9210 Morgan Road, AL-24-1

Please accept the following comments from El Paso County Public Health regarding the project referenced above:

Mike McCarthy
El Paso County Public Health
719-332-5771
08May2024

FLOOR PLAN

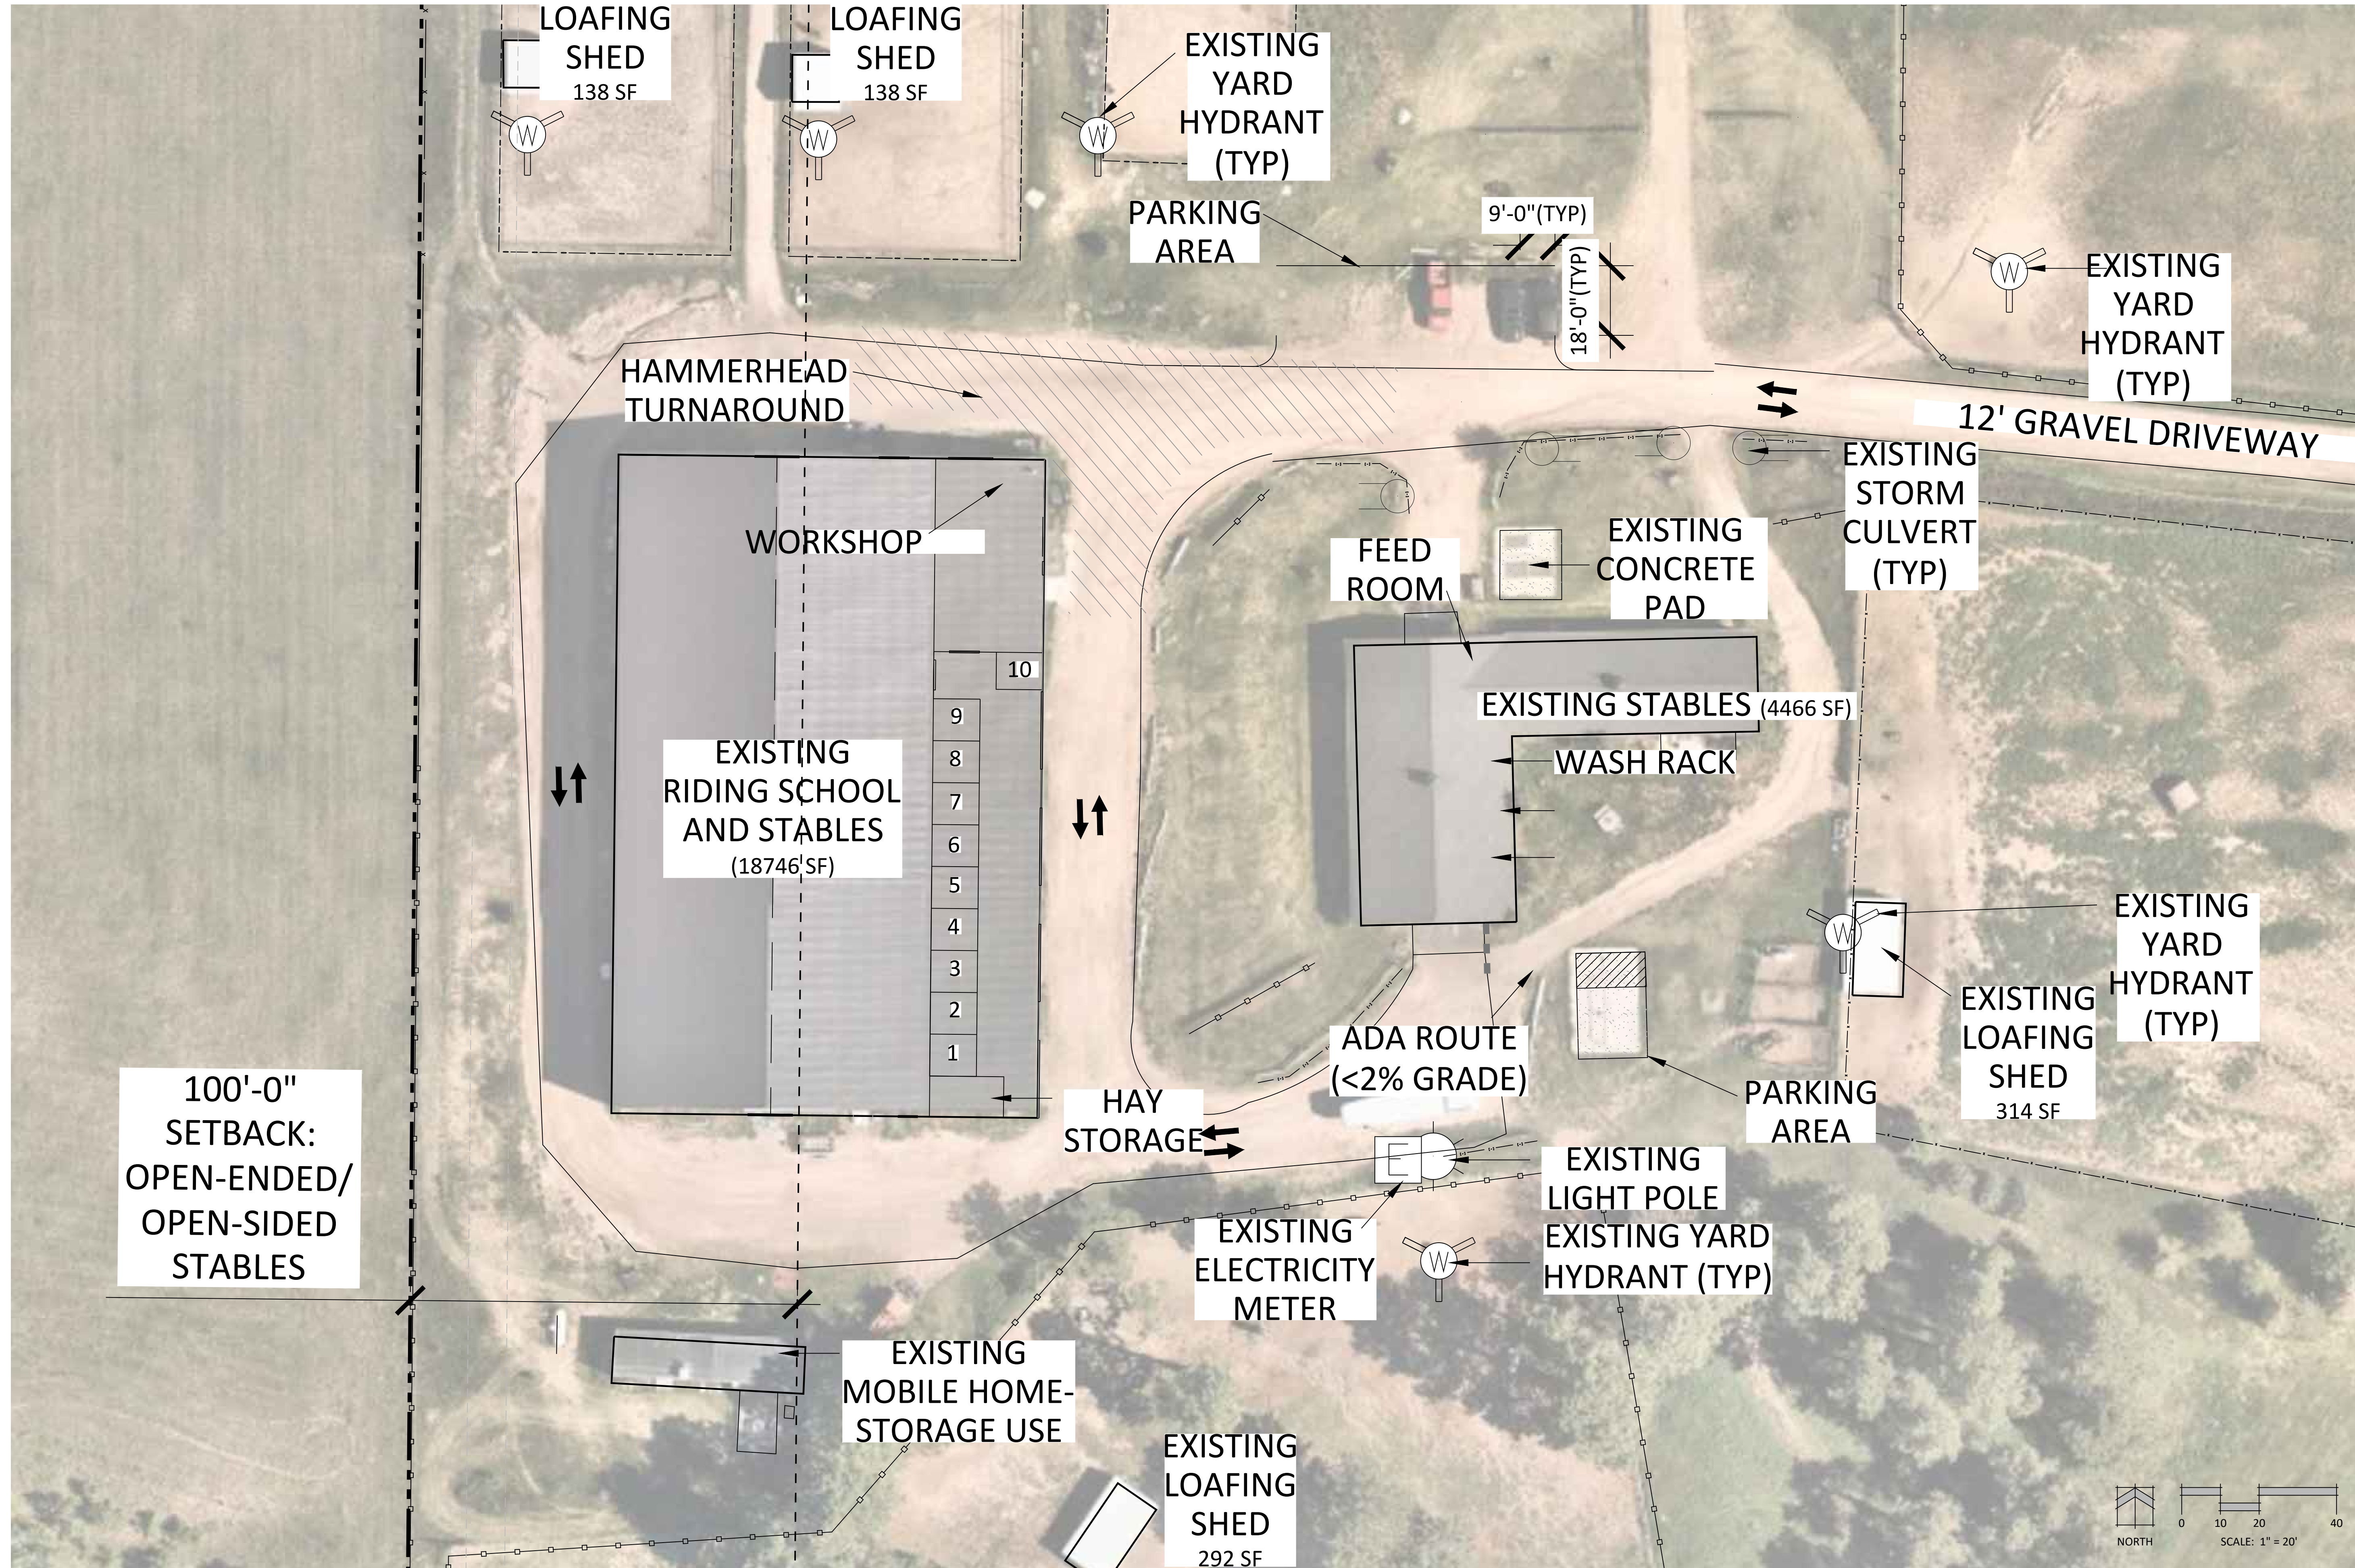
- The Site Plan indicated there is a laundry/bathroom located next to the commercial office/reception area. This special use cannot be approved until an OWTS engineer design is approved and an OWTS Permit has been issued by EPCPH. All requirements within the EPCPH OWTS Regulations must be followed.
